Case ref: EN0110012

Application by Light Valley Solar Limited for an order granting development consent for the Light Valley Solar

Advice following issue of decision to accept the application for examination

EN0110012/APP/LVS/06.02.15.10

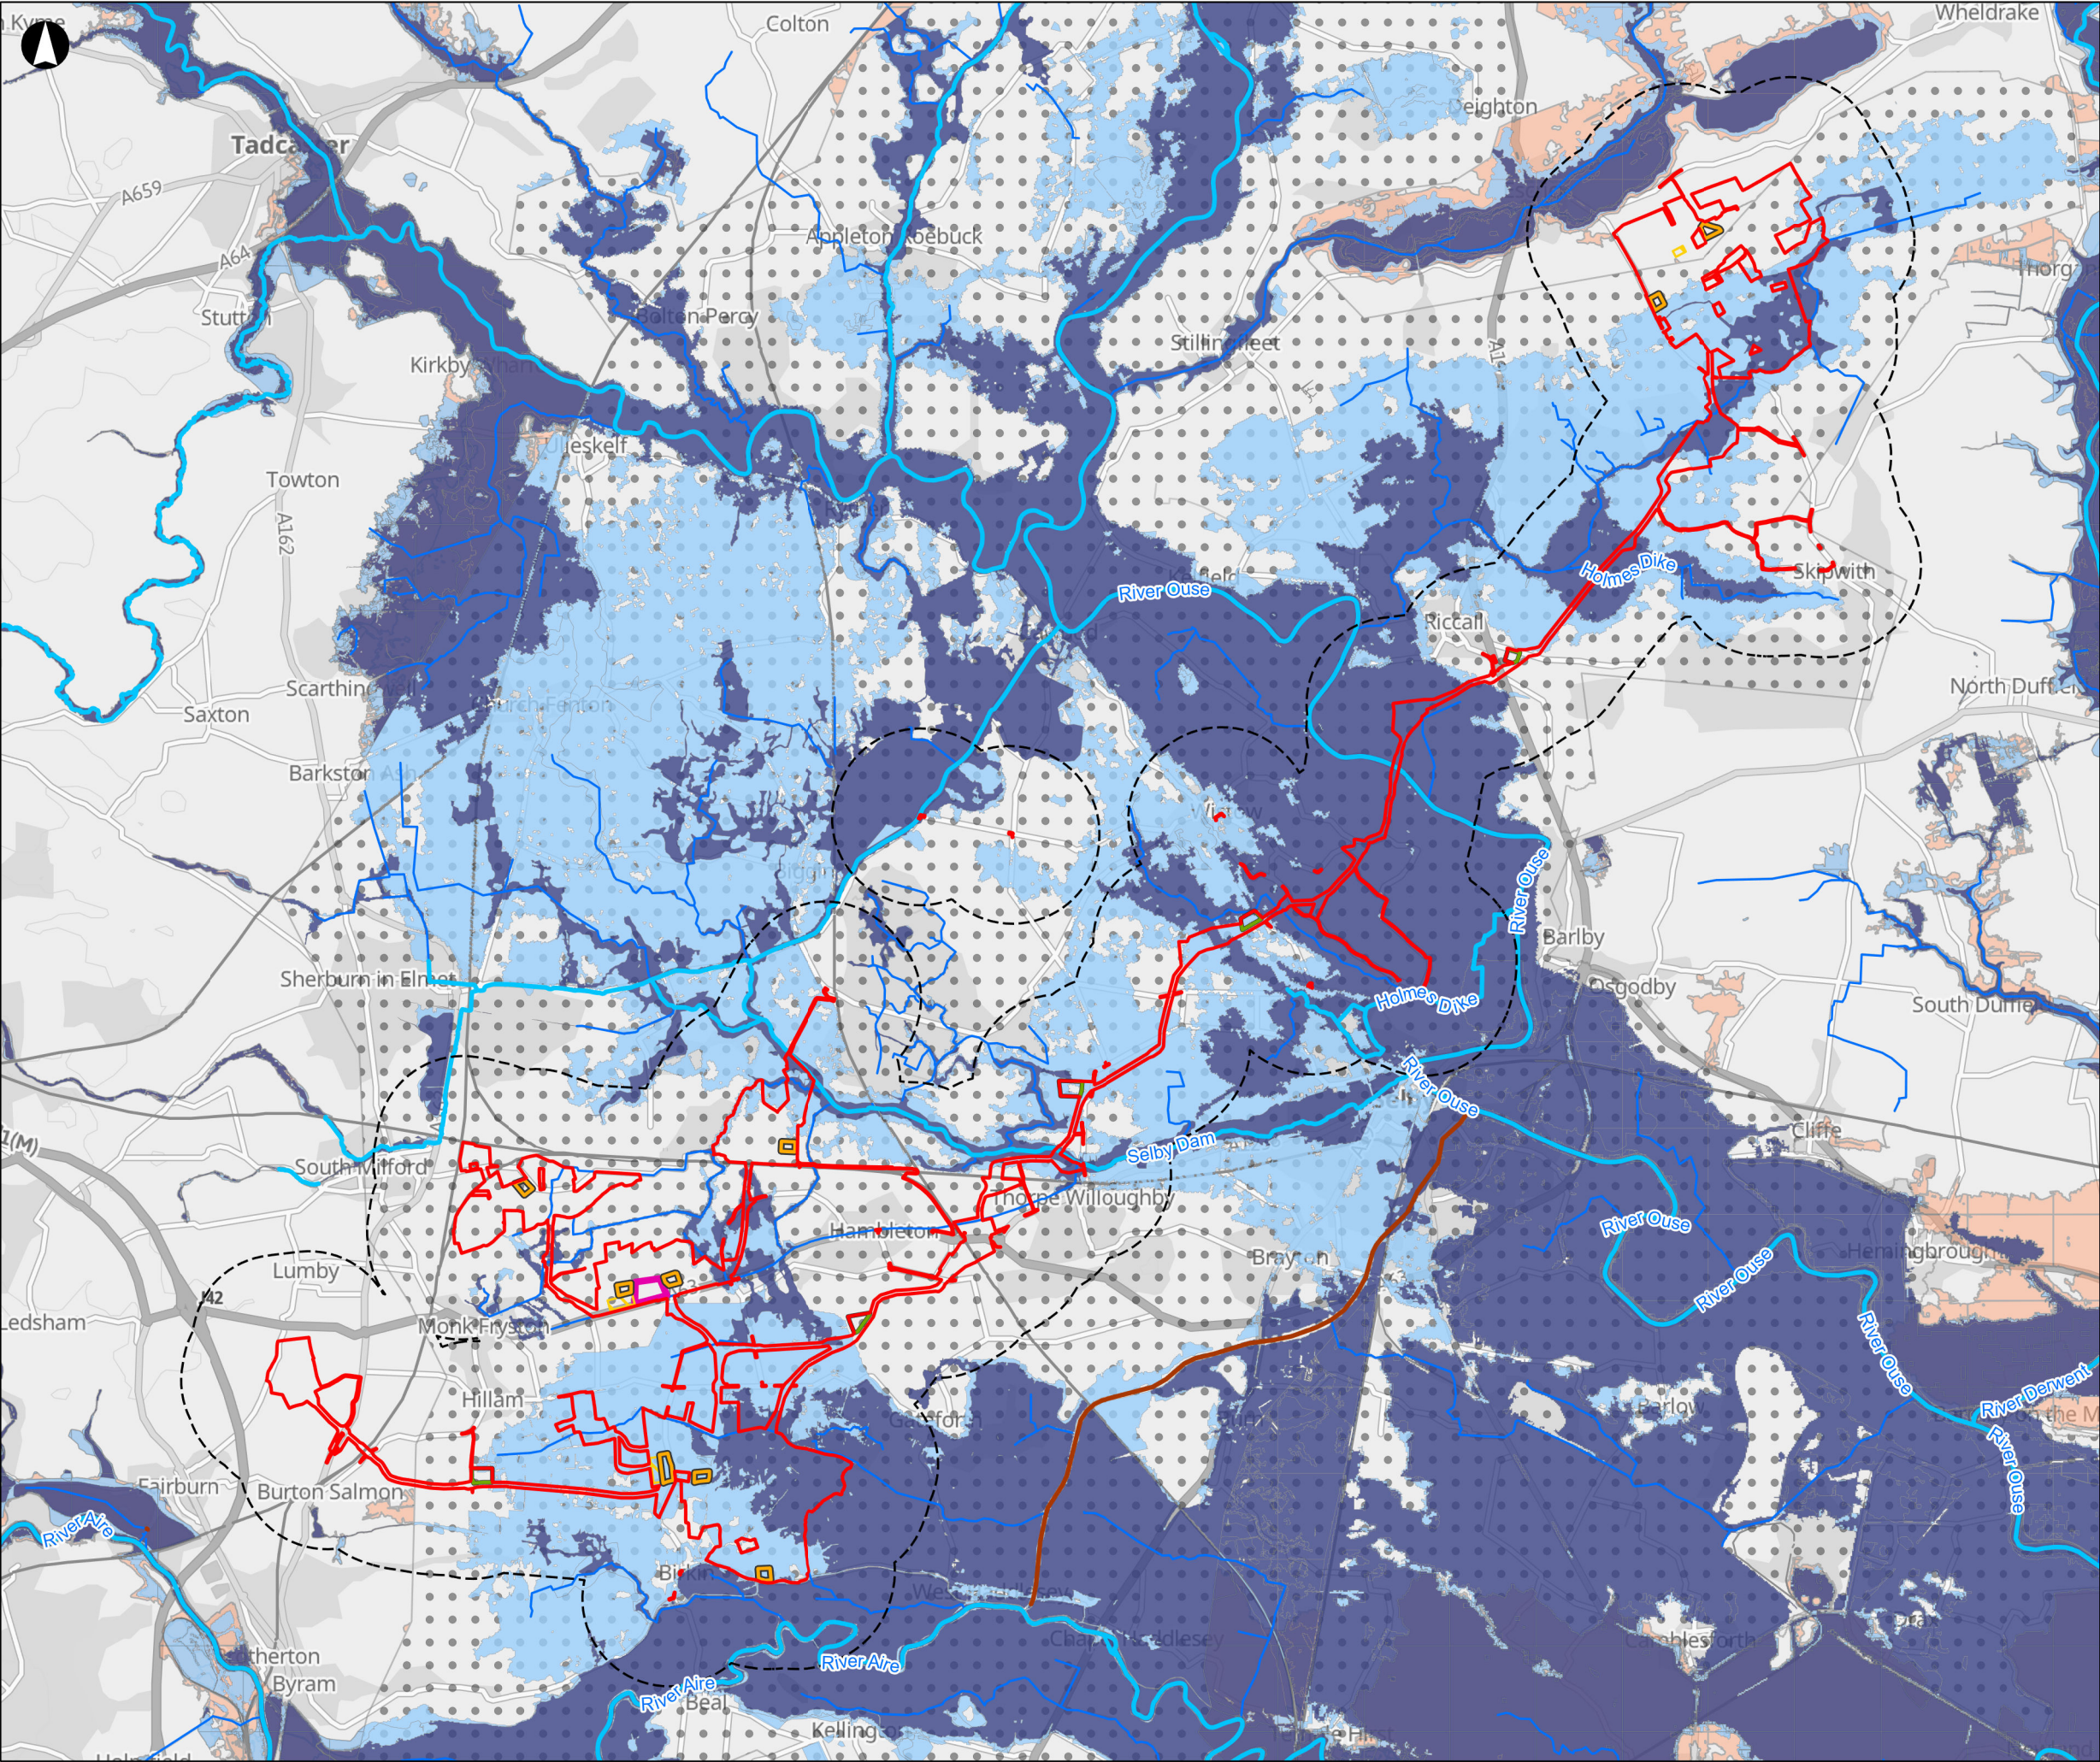
Section 7.2, as well as figures 15.10 and 15.14 of the FRA report, does not distinguish between Flood Zones 3a and 3b. A figure should be included in the Flood Risk Assessment distinguishing which areas of the proposed development's order limits are within Flood Zone 3a and Flood Zone 3b.
